**Application Number:** 2014-036                      **Application Date:** 04/07/2014  
**CBL:** 411 A007001                      **Application Type:** Zoning Contract/Conditional Rezon  
416-A-6-7-21  
**Project Name:** Casco Heights Condominium (Graves Hill)  
**Address:** 802- OCEAN AVE  
**Project Description:** Amendment to existing conditional rezoning agreement

**To:** FILE  
**From:** Barbara Barhydt  
**Subject:** Application ID: 2014-036  
**Date:** 6/4/2014

**Comments Submitted by: Marge Schmuckal/Zoning on 6/4/2014**

Drawing file: 1. Original Plans / Casco Heights - Building Elevations.pdf

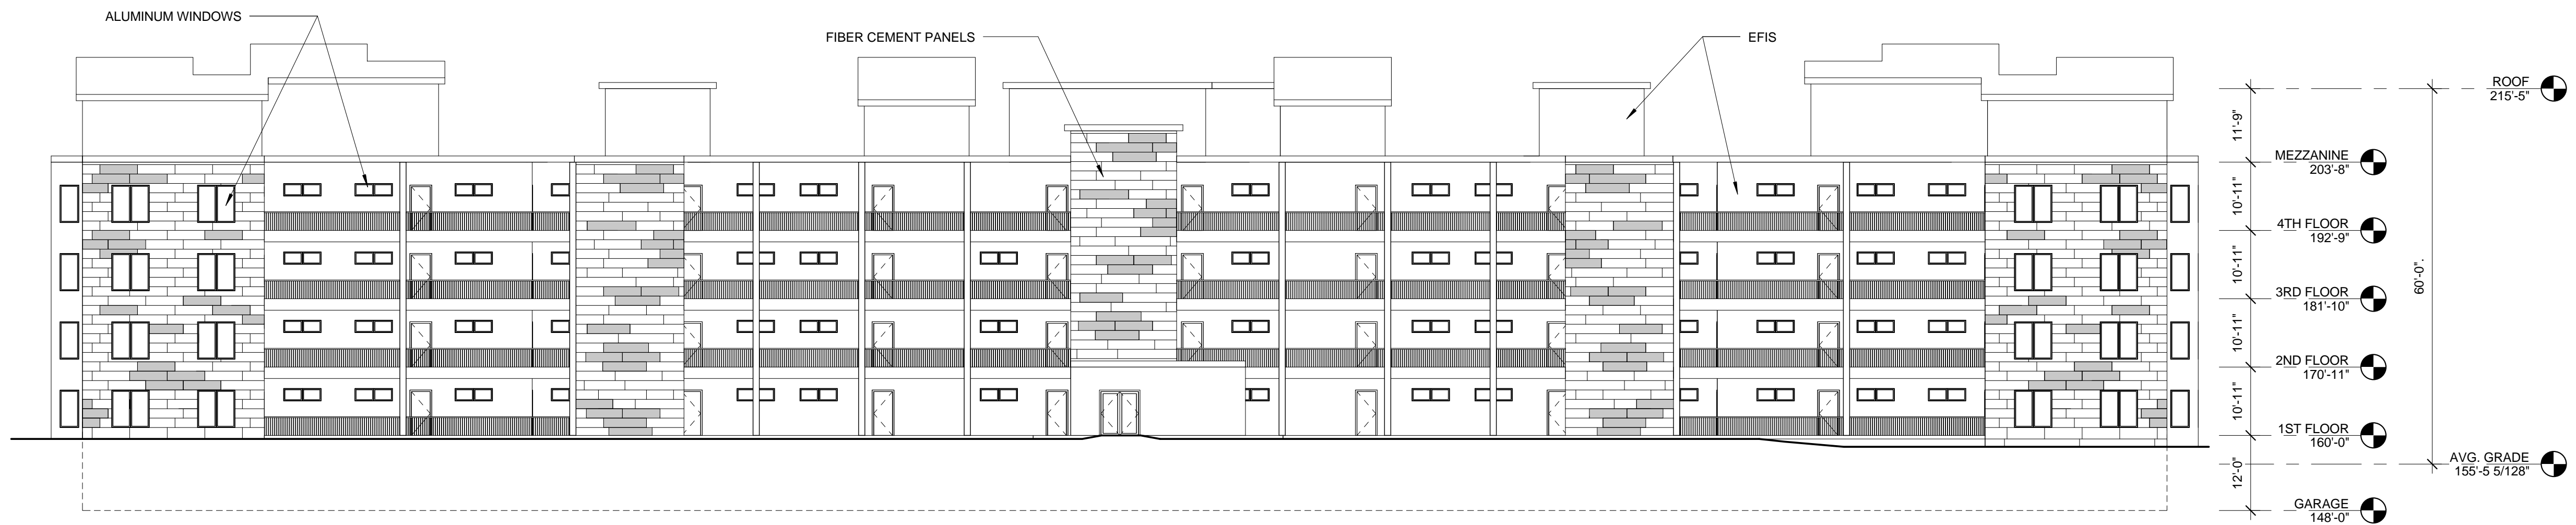
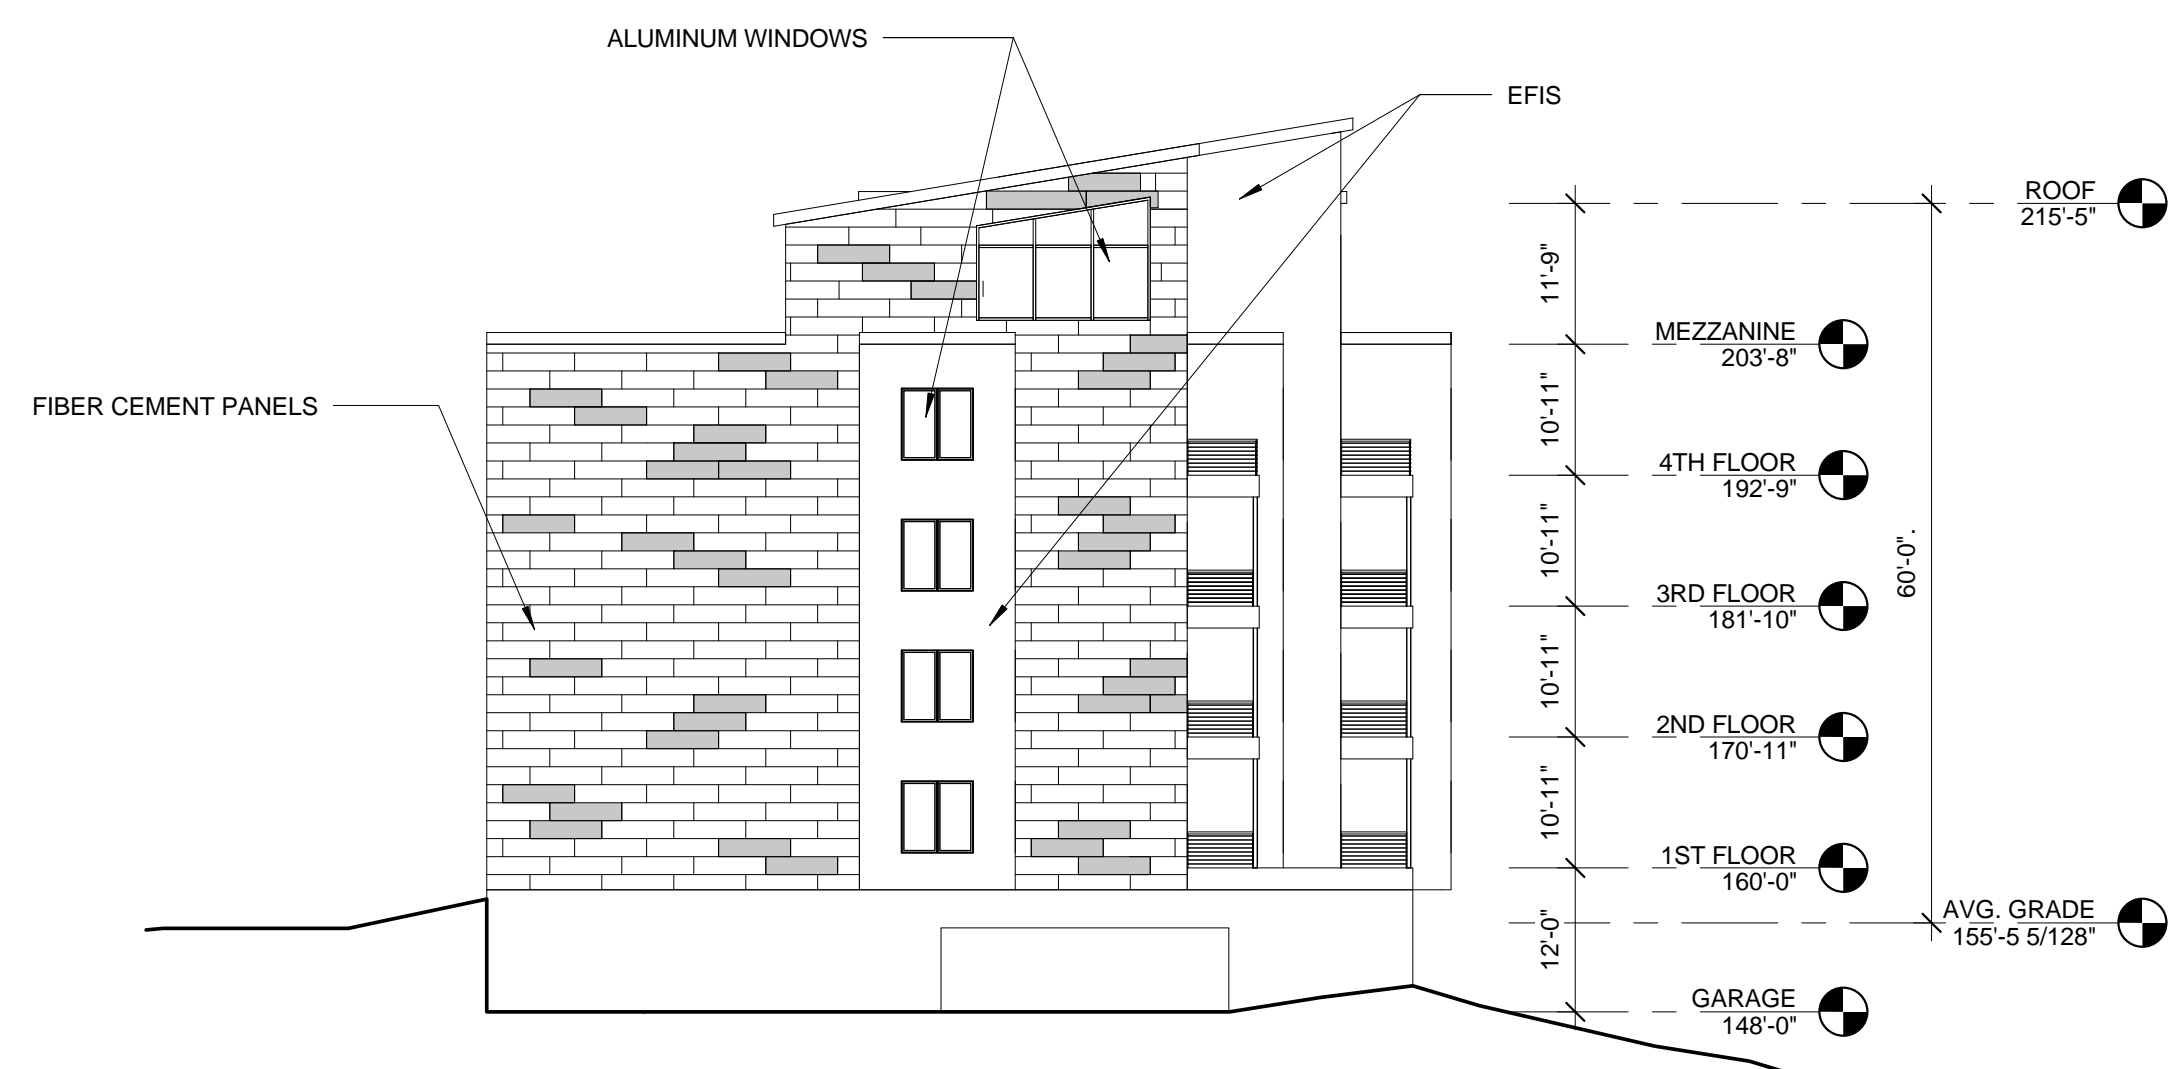
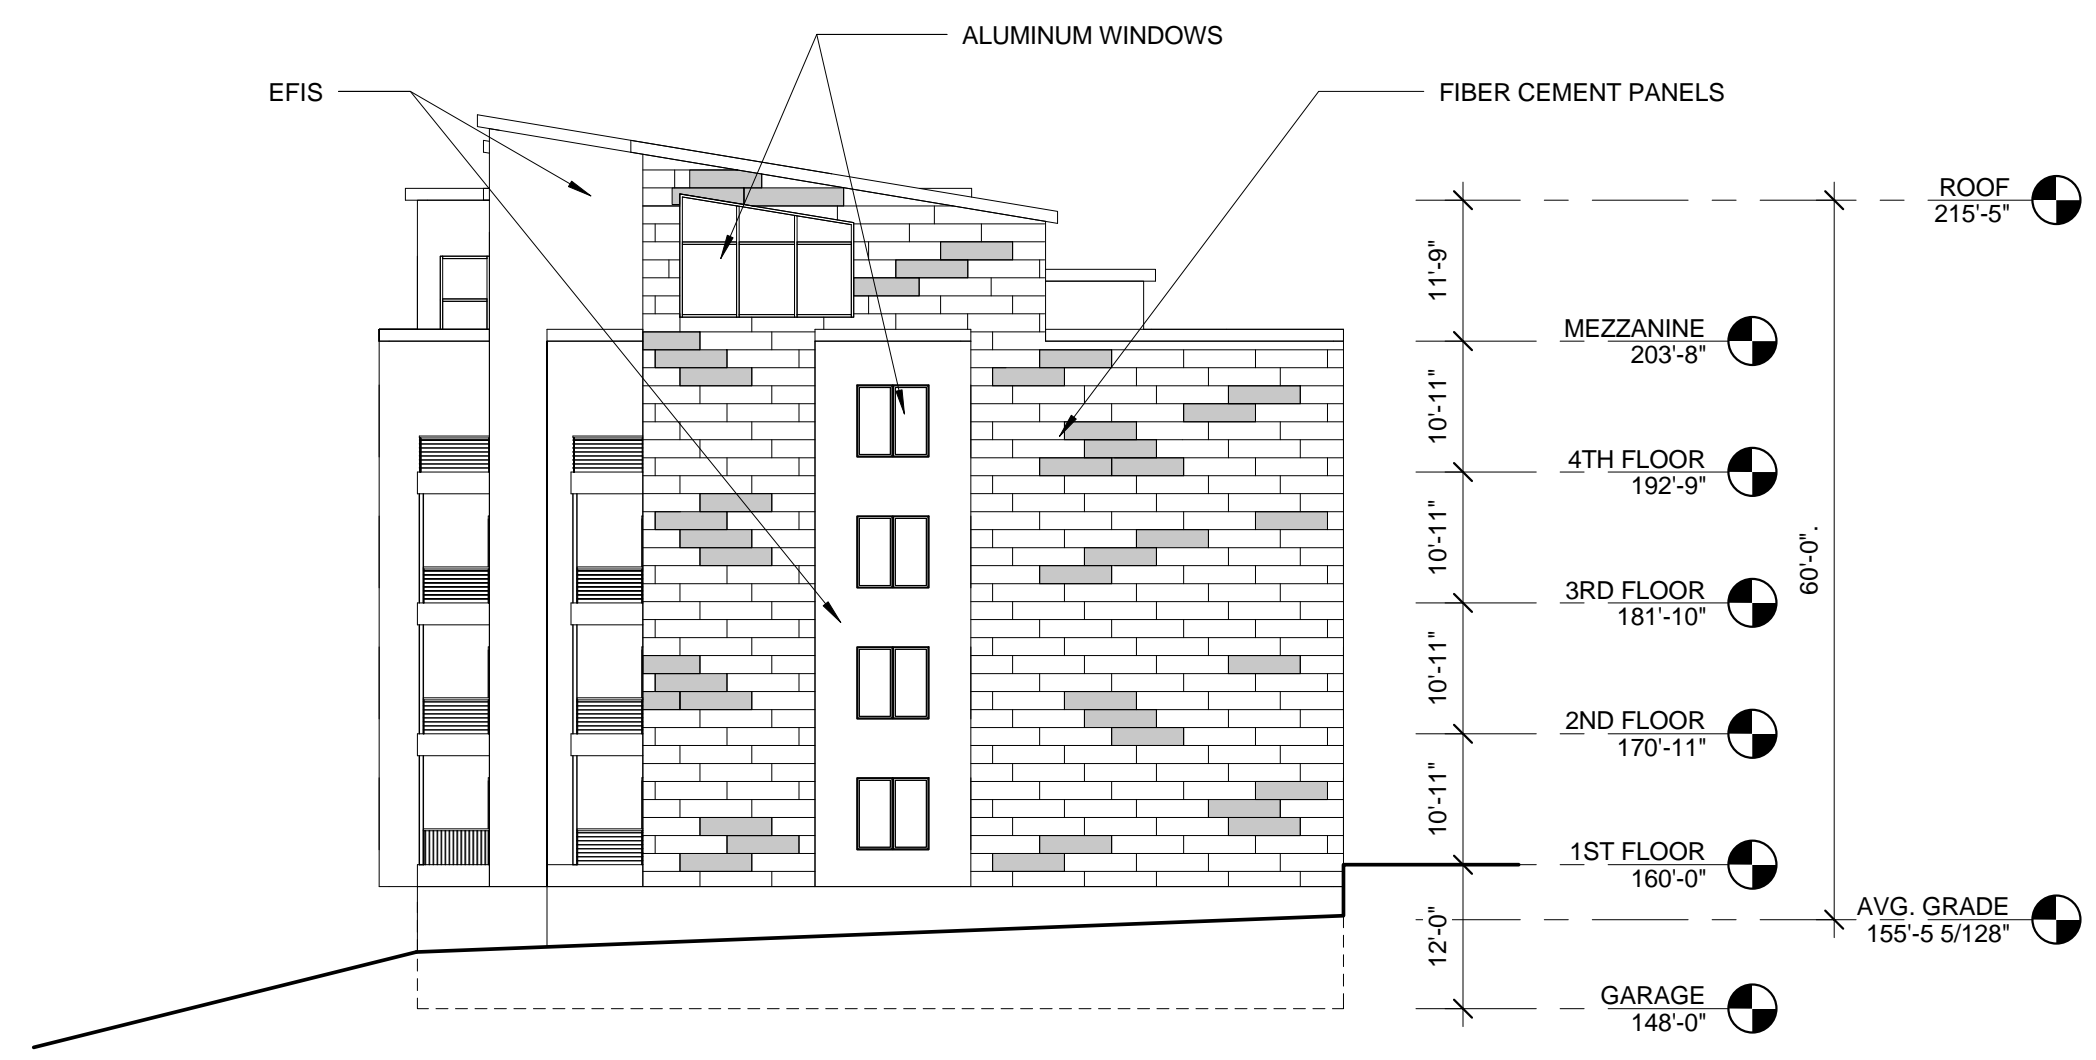
This amendment to the previous conditional/contract zone is reducing several of the dimensional criteria. The numbers of dwelling units is reduced from a total of 98 to 94 with 47 units in two buildings. The height is being reduced from 100' to 75'. The building elevations give an average grade of 1555'-5 5/128" (which I would like confirmed as to how that was determined). The height given on those elevations is 60', well within the 75' height proposed.
